SOUTH HOLLAND DISTRICT COUNCIL

Purpose: To consider Planning Application H02-0336-22

Description: Proposed residential development, replacement allotments and new cemetery, including woodland burial plots, associated infrastructure and new accesses - approved under H02-0586-21. Modification of Condition 1 to allow amendments to previously approved plans.

Location: Parish Mews Crowland

DRAWING TITLE:
S73 - SITE PLAN AND OVERLAY

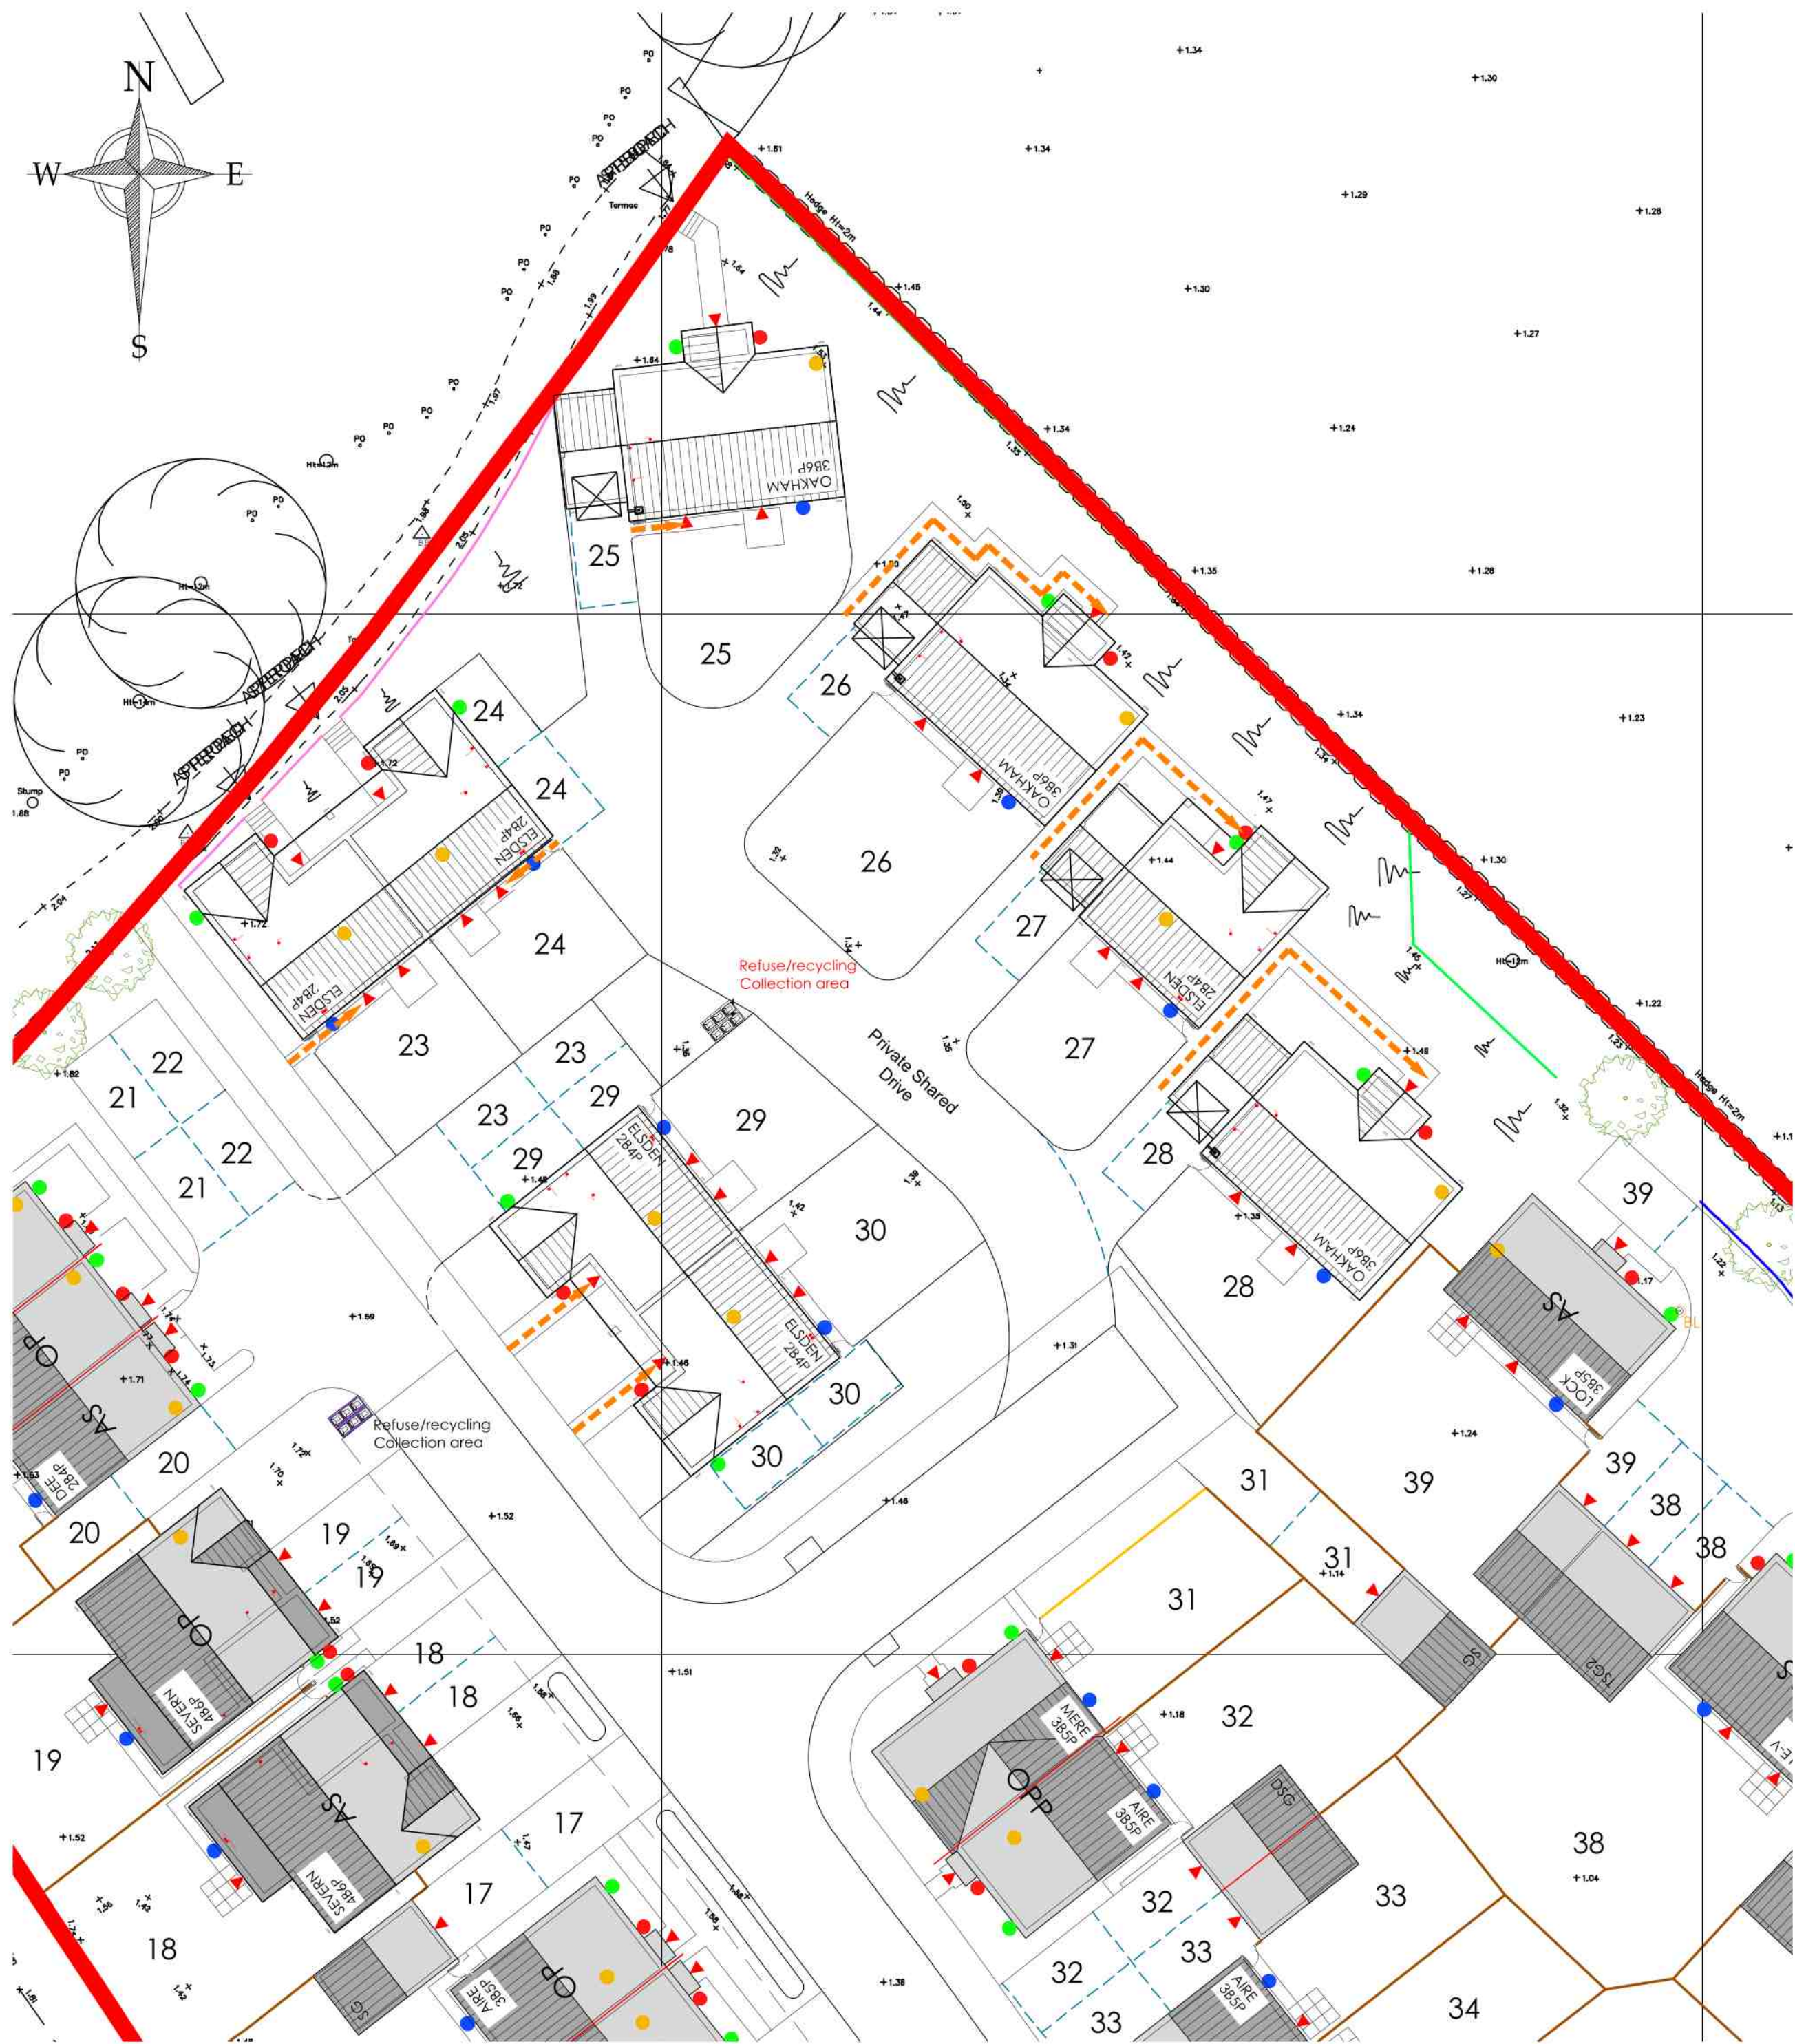
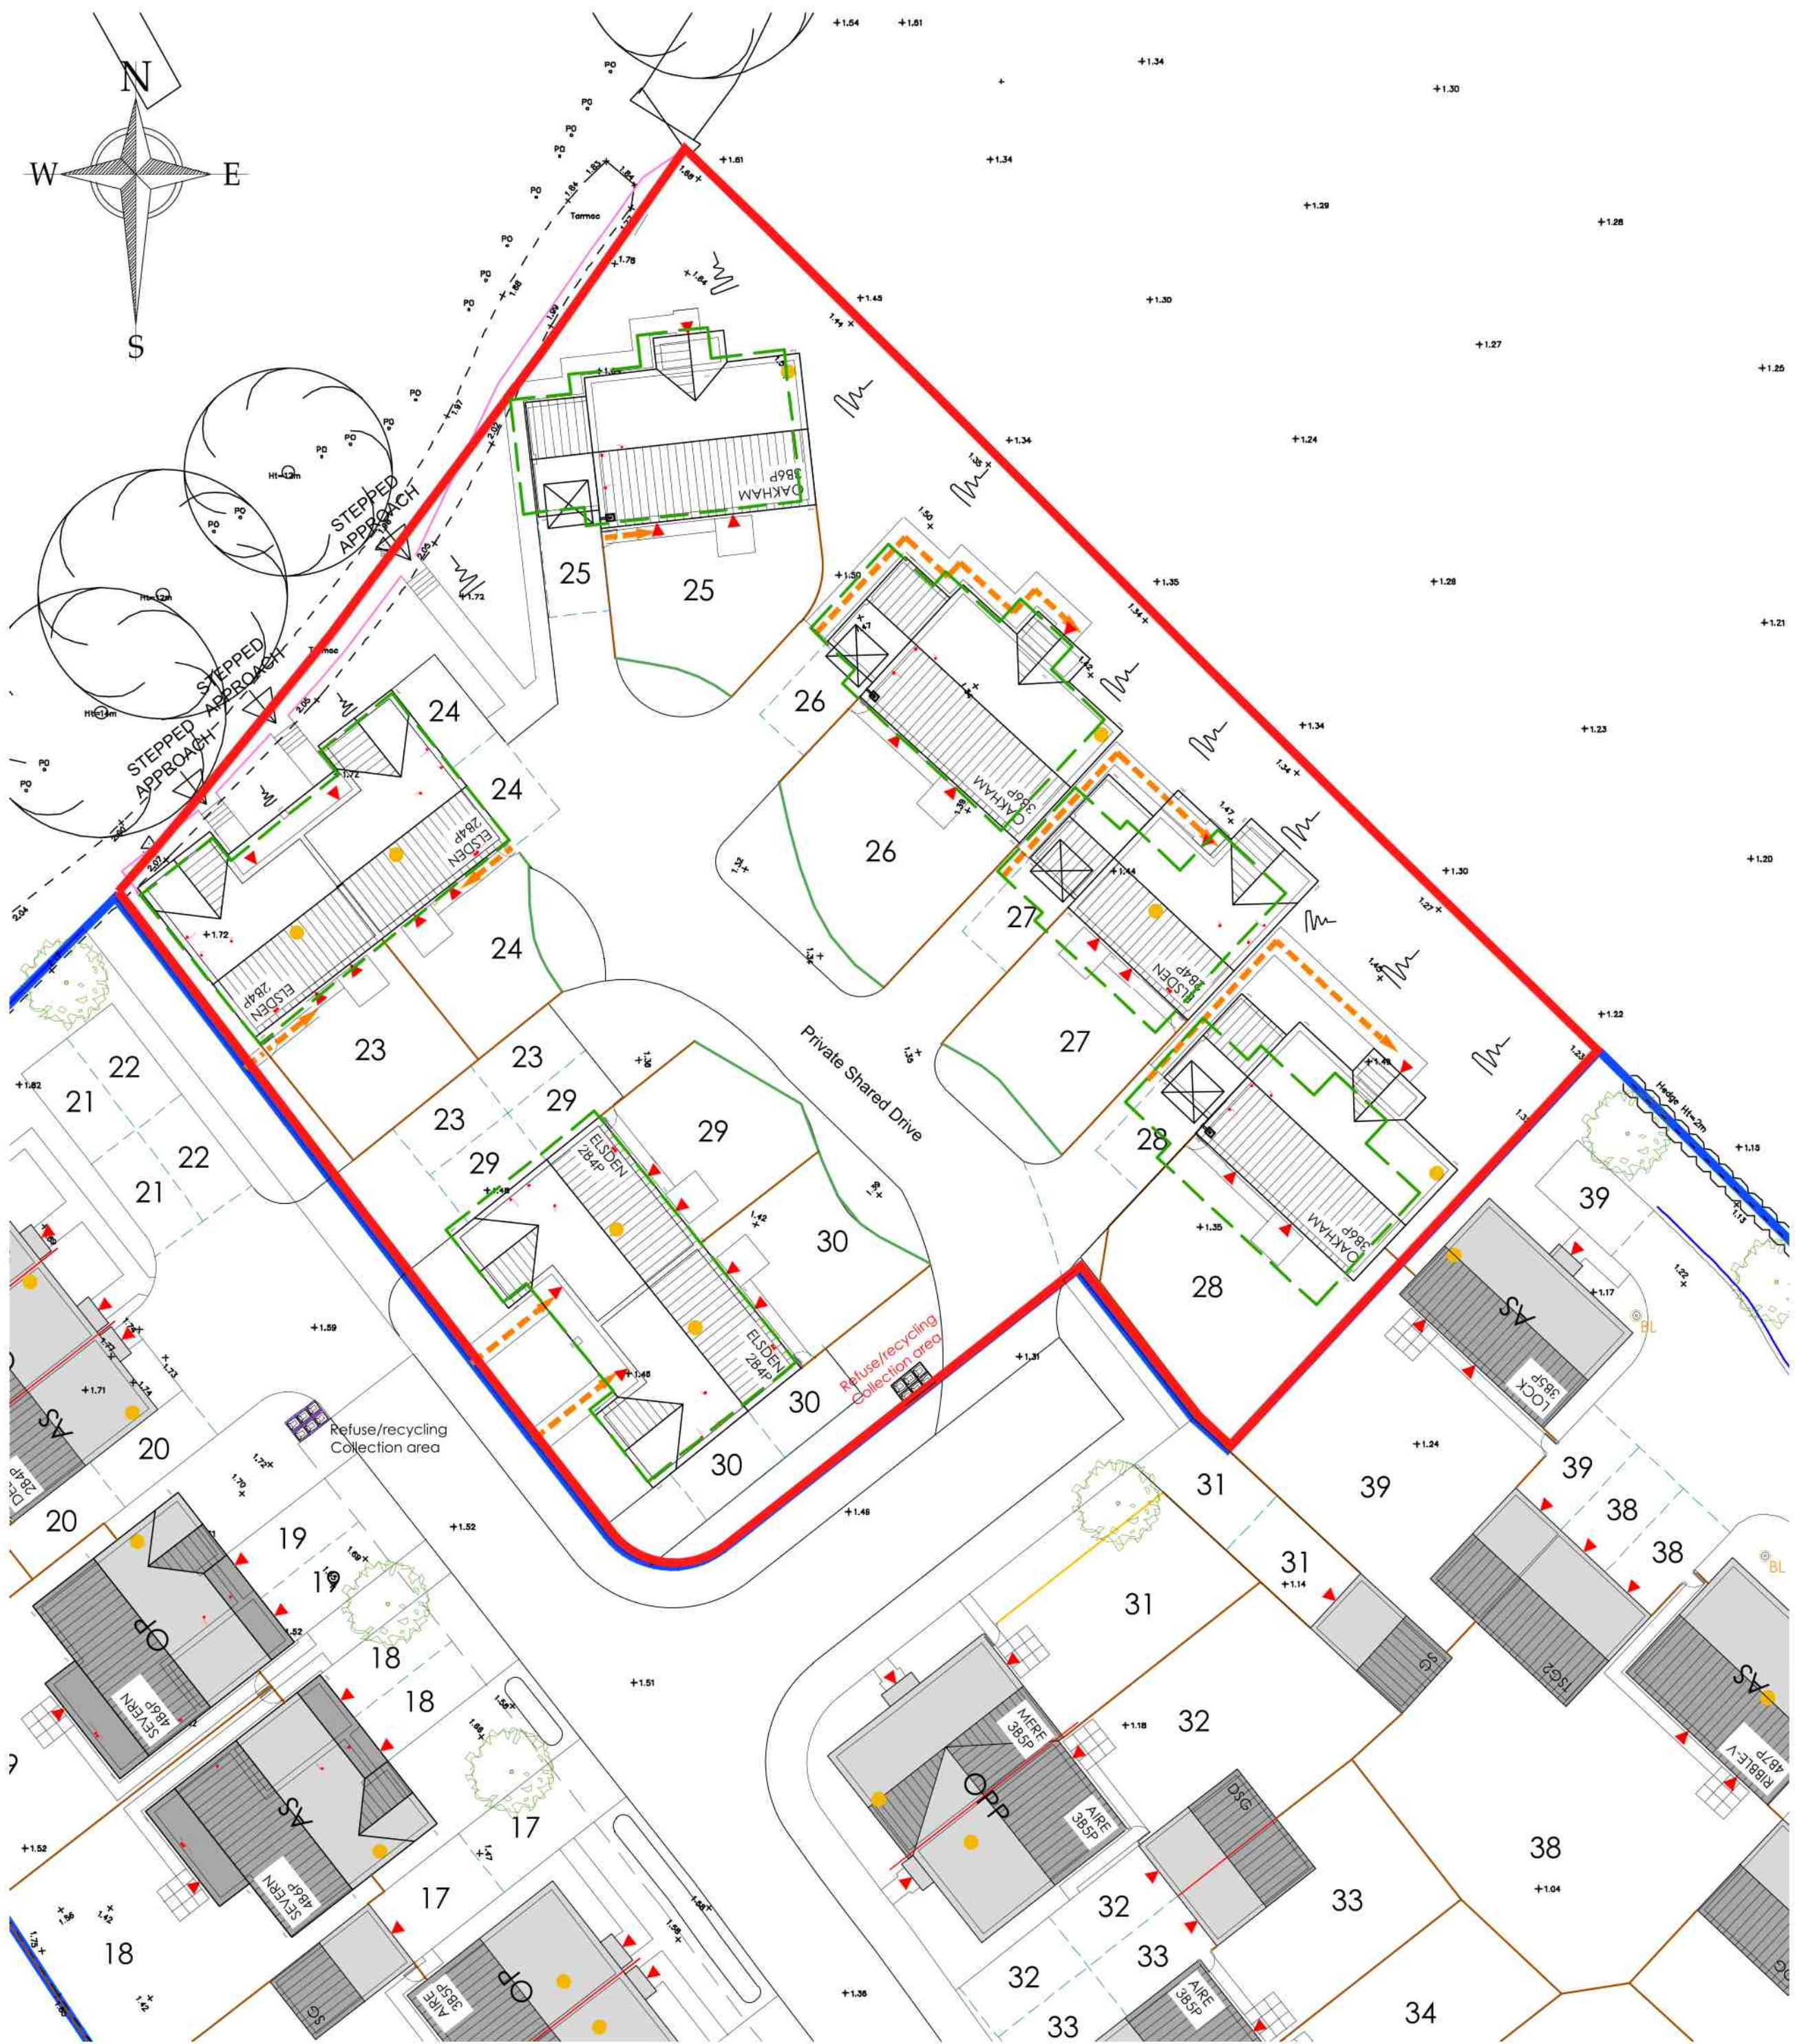
7.3 This application seeks permission to formalise the as-built positions of the properties on Plots 23-30. The properties on Plots 23, 24, 25, 26, 29 and 30 would be repositioned marginally and

are not considered to have a material impact on the site as a whole. The property on Plot 27 would move approximately 1.5m north-east and the property on Plot 28 would move approximately 2m north-east. The repositioning of the two properties would not materially impact the character and appearance of the streetscene or surrounding area. Furthermore, the properties would not be repositioned further than the rear elevation of their respective neighbouring properties.

7.4 The housetypes, landscaping and boundary treatments would remain unaltered as a result of this application, other than the removal of the protected tree. The recommendation to grant this retrospective application is not to be taken as condoning in any way the actions of the developer in removing the protected tree and might not otherwise have granted planning permission for the altered location of the dwelling had it resulted in the loss of the protected tree. The Council is currently prosecuting the developer for this action. Outside of the determination of this planning application it has been agreed that the developer will plant two replacement trees on Parish Council land.
